From: Rhiannon Lloyd
Sent: 20 November 2024 12:24
To: [REDACTED]
Subject: RE: R/196/24/CLP - 21 Mill Lane, Rustington - Lawful Development Certificate

In light of the application type, I believe that the factors below indicate that it is a material change of use and the application should go to planning instead of an LDC. I hope you will consider these factors and recommend that the application go to planning.

Drawn by : MISCHA
	Client : MR & MRS HUBBARD
	Drawing Title : PL PLAN
	Scale : 1:50 @ A3
	Date : 30 September 2024 14:34:11
Drawing Reference : 3500.24 - HTB- PLPL - OPT2B	
Revision Number : -

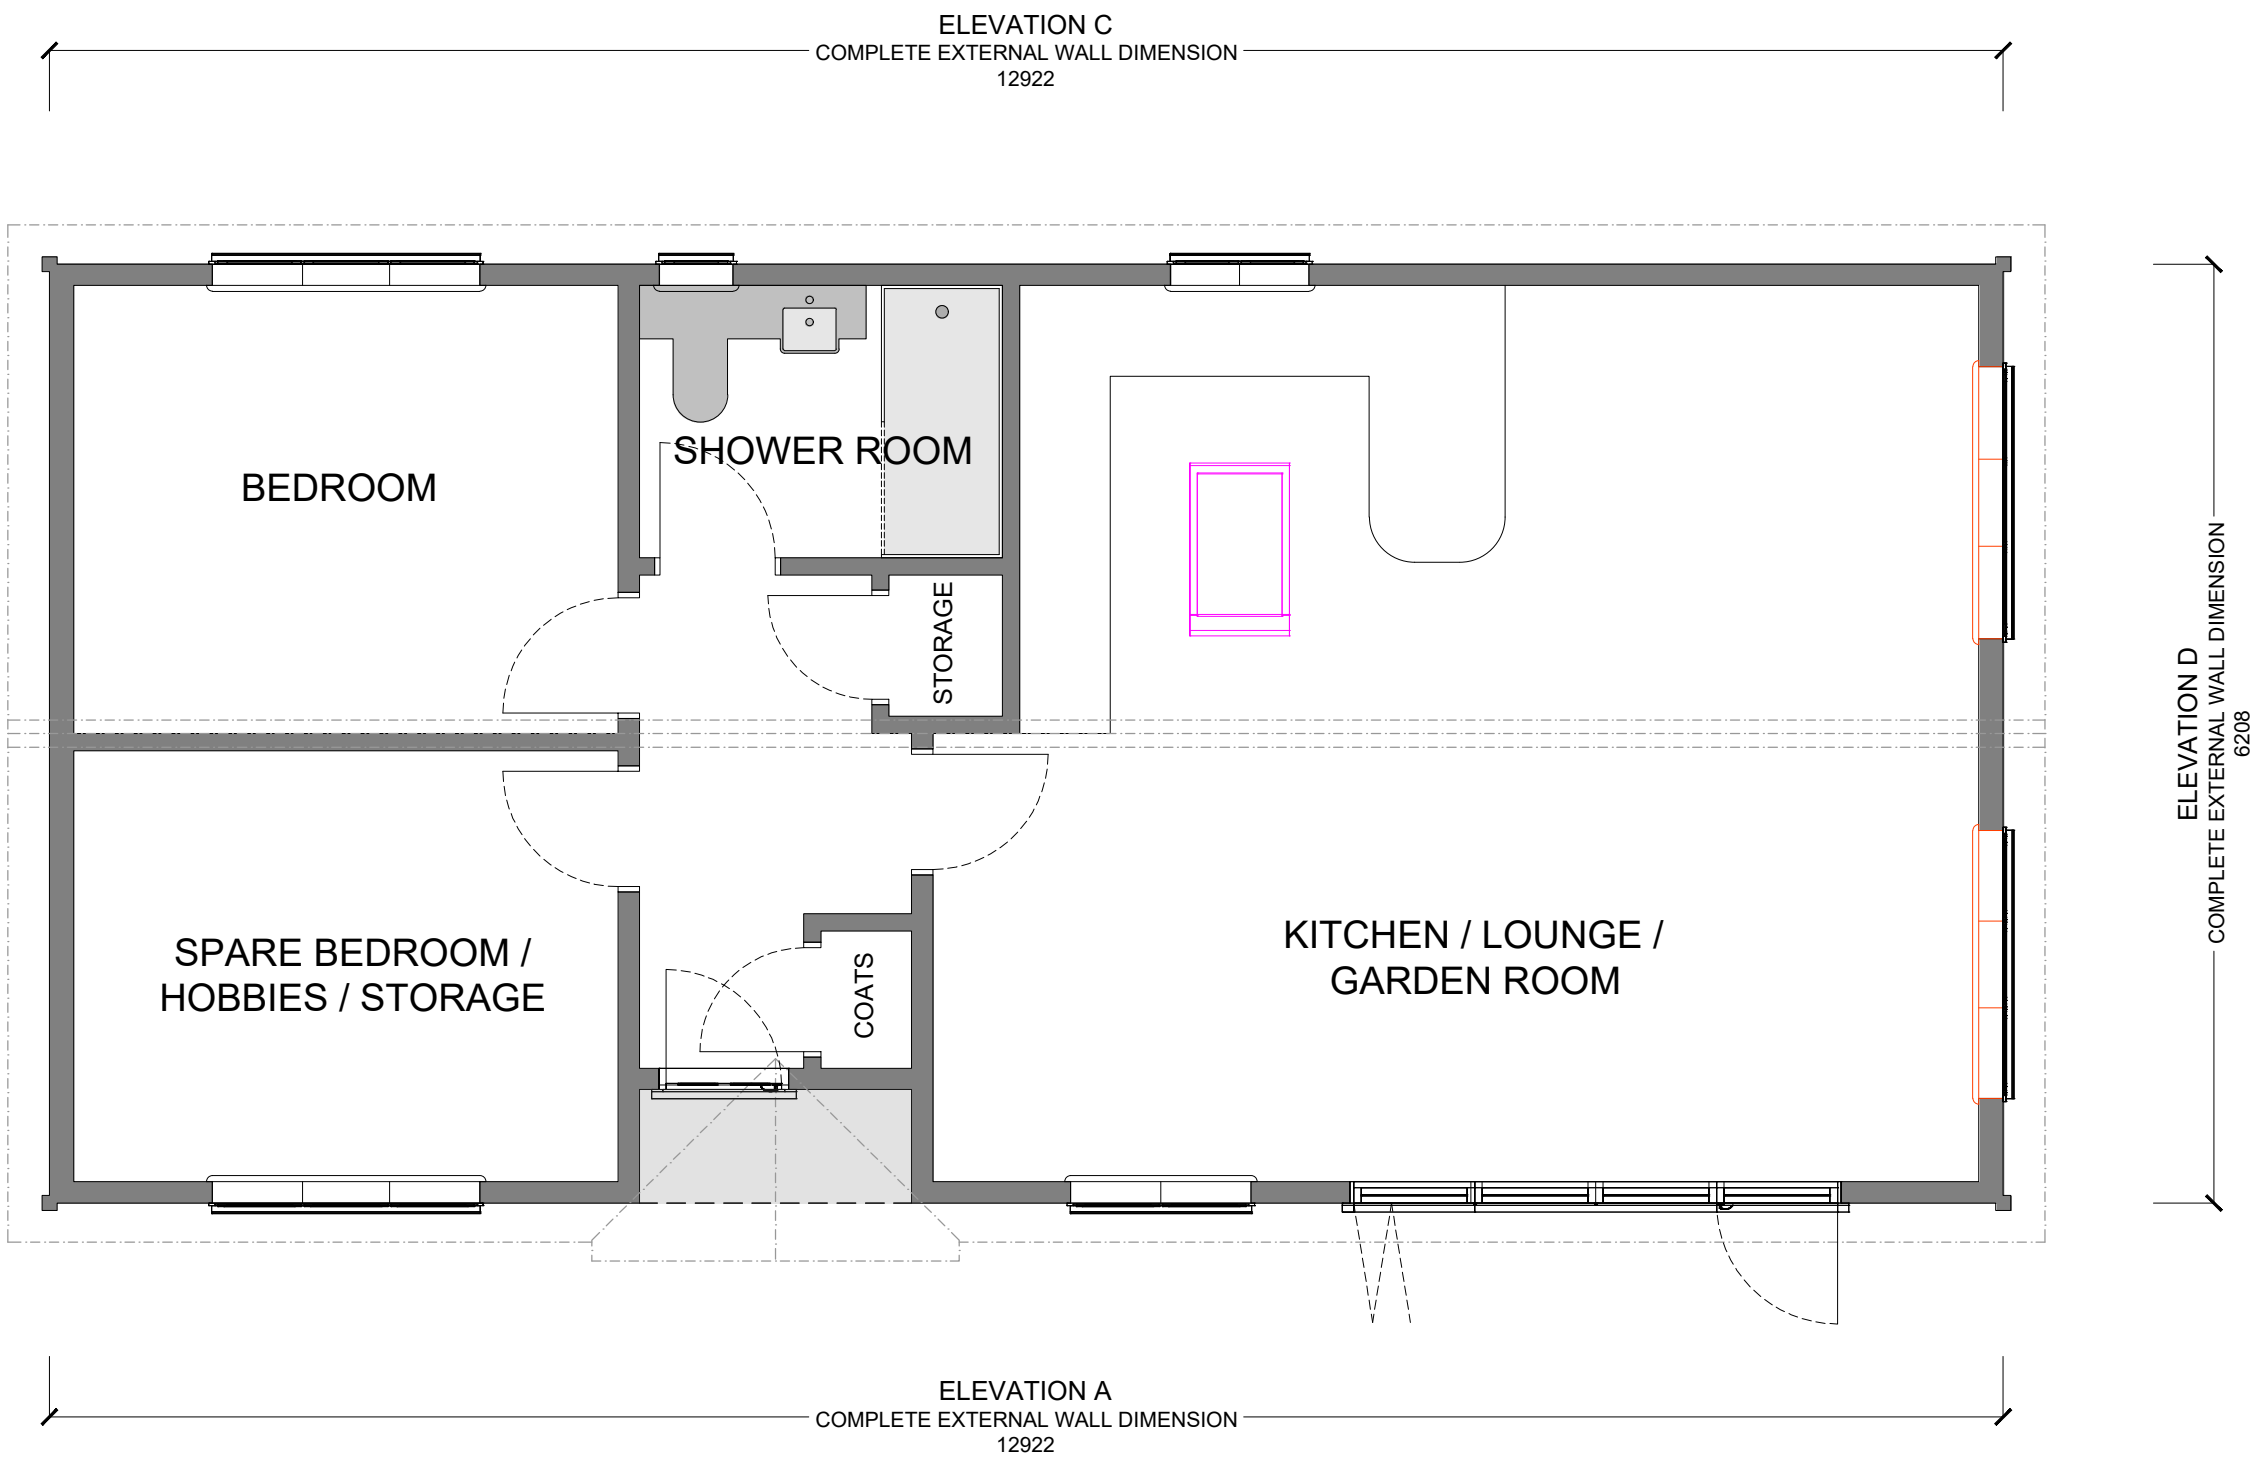
Proximity to the main dwelling: The mobile home caravan is positioned as far away as possible from the main dwelling (about 40m), making it difficult for family members and those residing in the mobile home, with reduced mobility, to gain access to the main dwelling conveniently. This remoteness will result in reduced care and support from family members residing in the main dwelling.

Privacy: The mobile home caravan is located in an area of the garden that will overlook neighbours on three sides. Two of the sides have windows directly facing neighbours. This does not maintain the privacy of the residential setting and does not take into consideration neighbours' privacy.

Visual impact: The chosen location of the mobile home caravan has a large visual impact on the surrounding area and neighbouring properties. The proximity of 1m or less to each boundary and the height of at least 3.57m is far higher than the boundary fences surrounding it. There is no space for screening on the property because of the closeness to the boundary, which places the burden on neighbours to perform the screening themselves on their own properties, to reduce the visual impact. There is a high visual impact and the look and feel of the neighbourhood will change from within neighbours' private gardens.

From the plans, the mobile home will be 1m from our boundary and 3.57m high and will face back towards the rear of our dwelling. We are concerned about being overlooked and also having light pollution in the rear garden and hope that the Council would consider adding provisions to alleviate these concerns:

Therefore, effect on neighbours is not formally considered when assessing this type of application, as per the legislation.

We appreciate the applicant's desire to screen and reduce light from the outbuilding, however this is not something that is taken into account during the Council's decision-making process for Lawful Development Certificates.
